Our ref: MP 10_0158

Major Project 10_0158 – Residential Development Buildings 7 & 8, 61 Mobbs Lane, Epping

ADDITIONAL INFORMATION REQUIRED

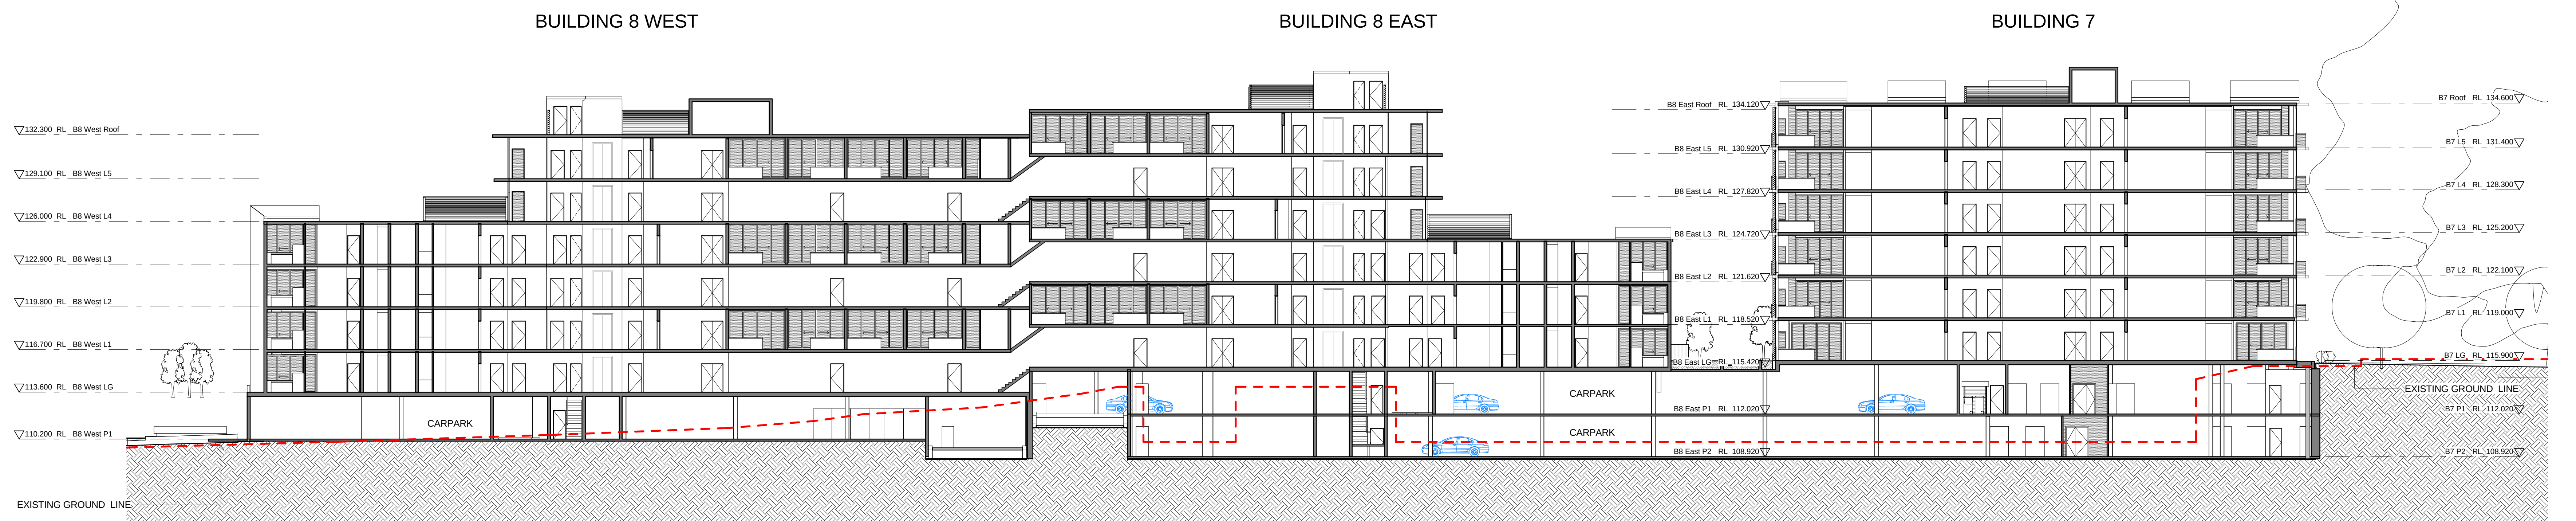
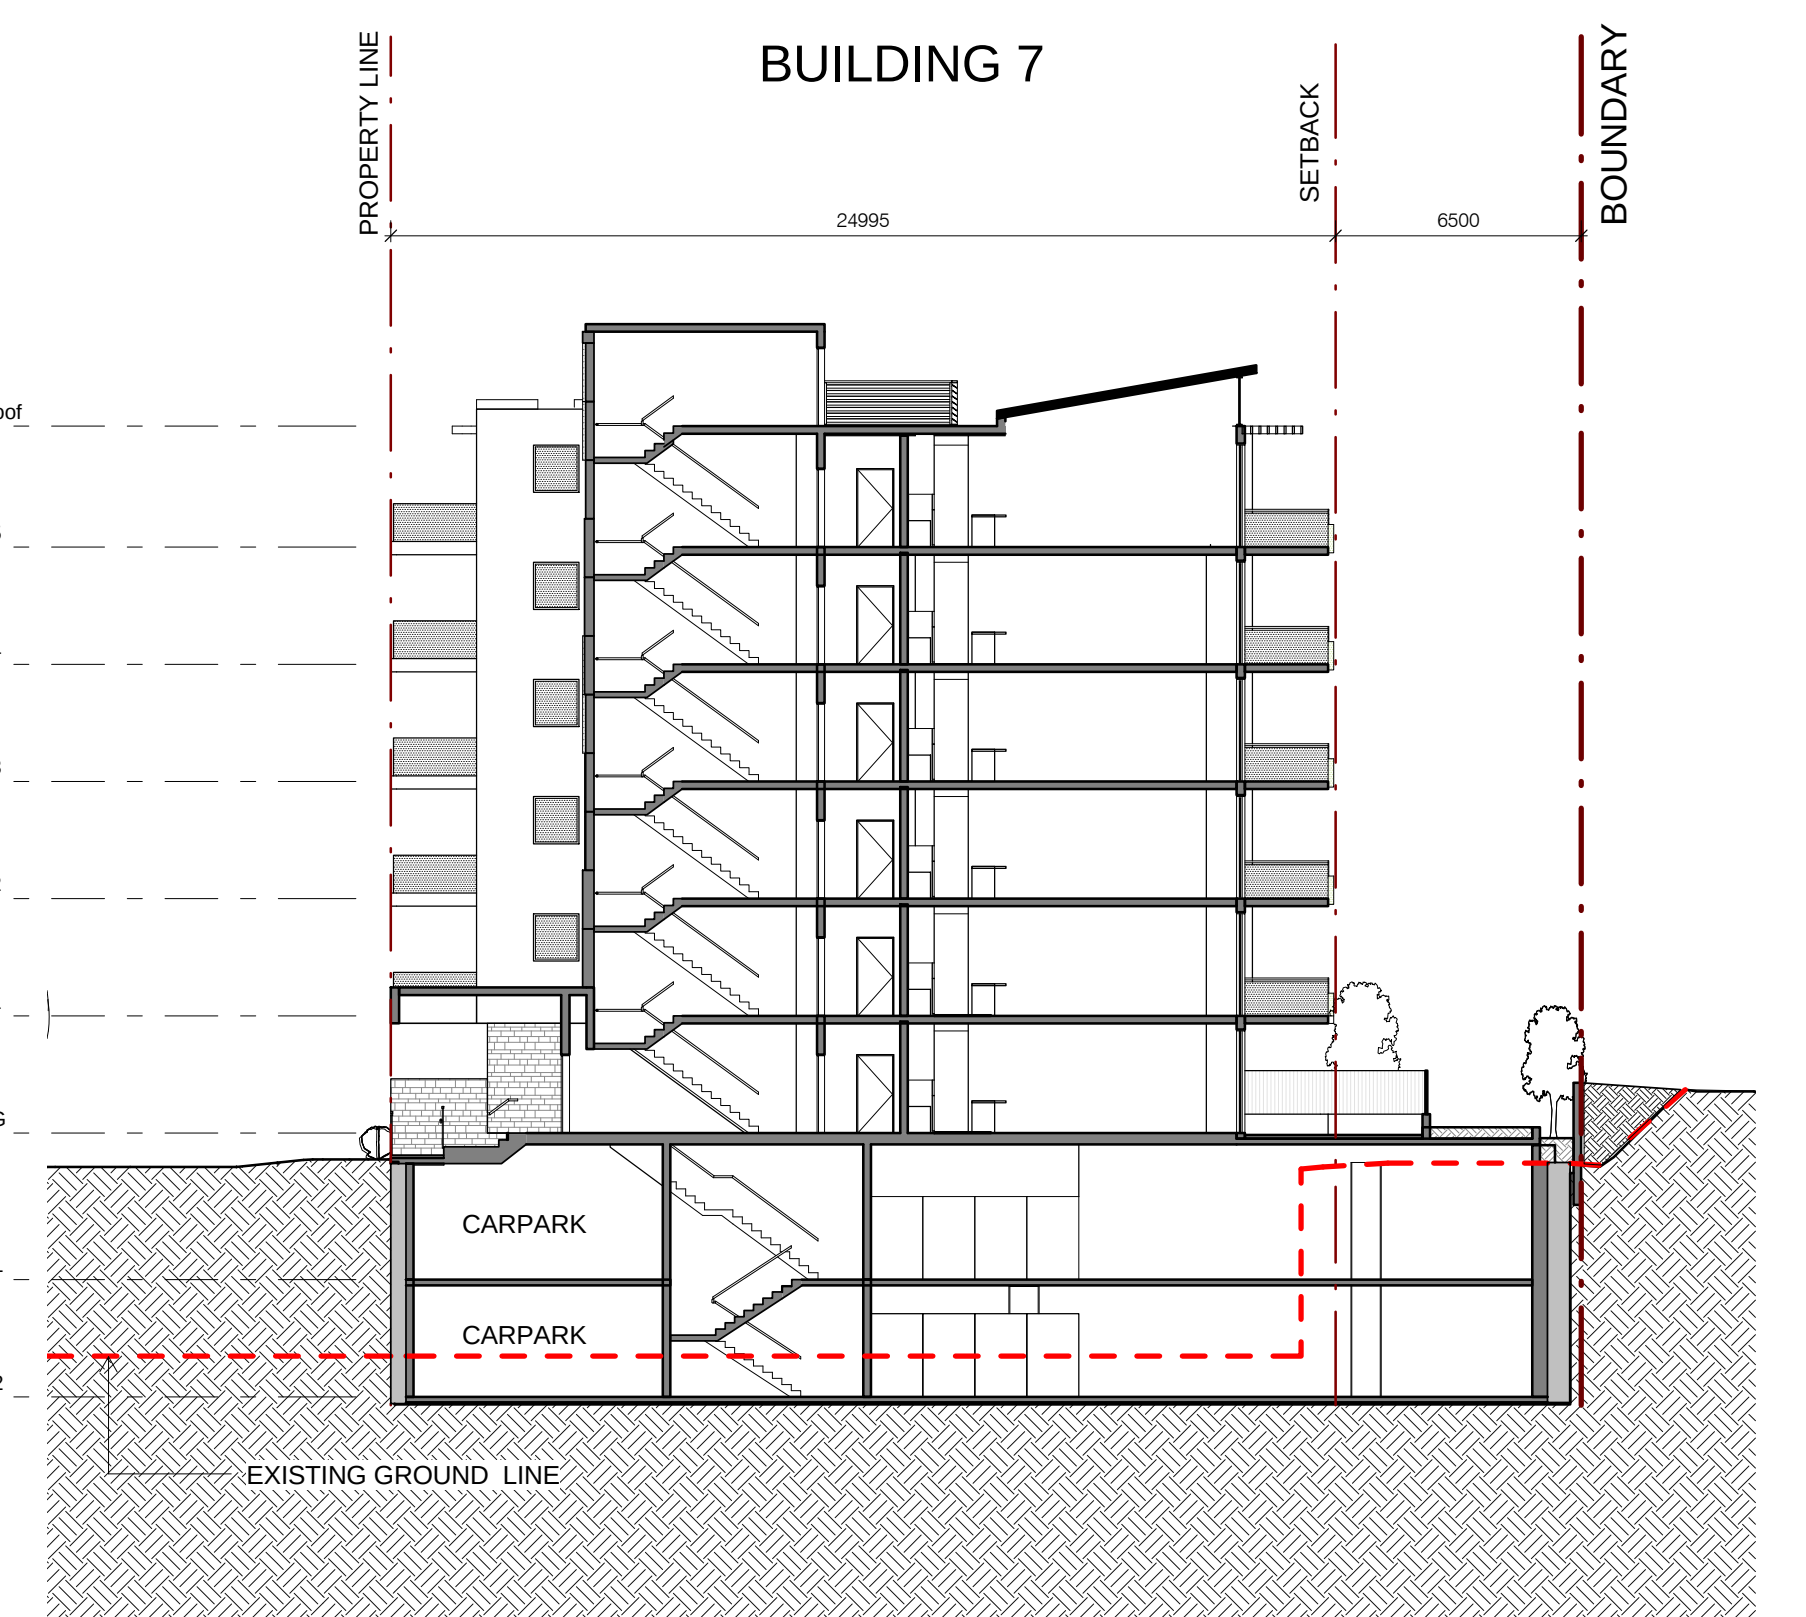
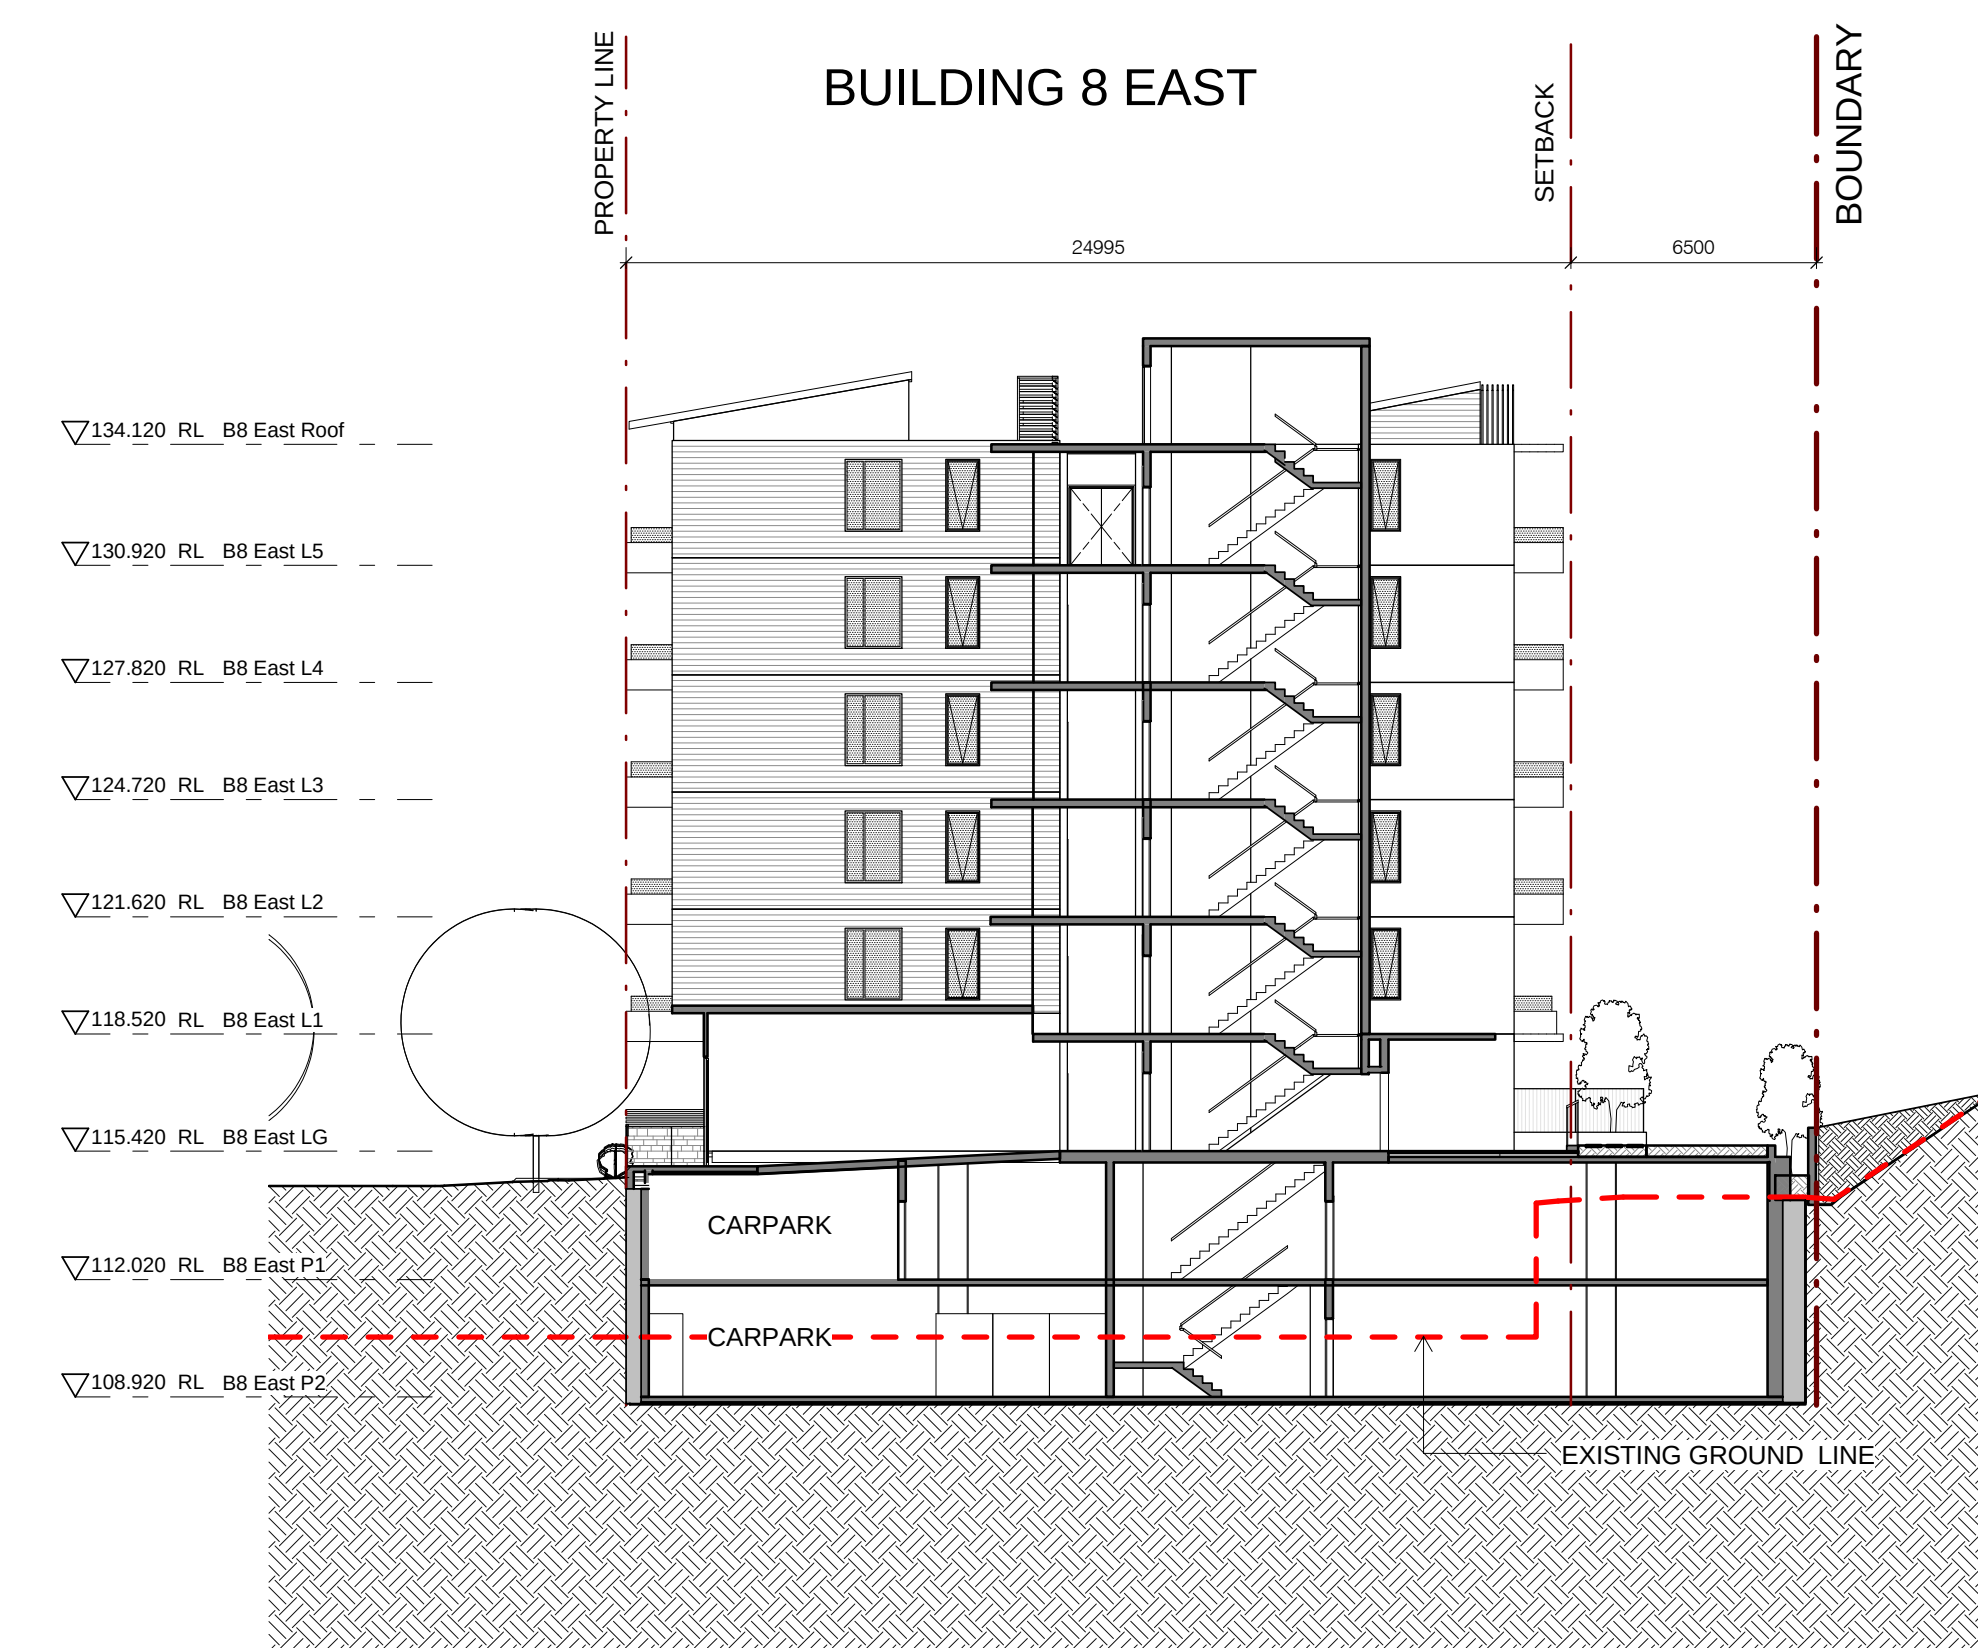
Concern is raised regarding the height of the western part of Building 8. This part of the building appears to exceed the 6 storey height limit prescribed under Schedule 3 of SEPP (Major Development). The height of the building should be reduced to comply with the SEPP's height controls. Furthermore, basement projections should not exceed 1.2m above natural ground level.

All revised drawings are to be submitted at an appropriate/accurate scale on A1 sheets. All elevation plans shall indicate existing natural ground levels and proposed natural ground levels.
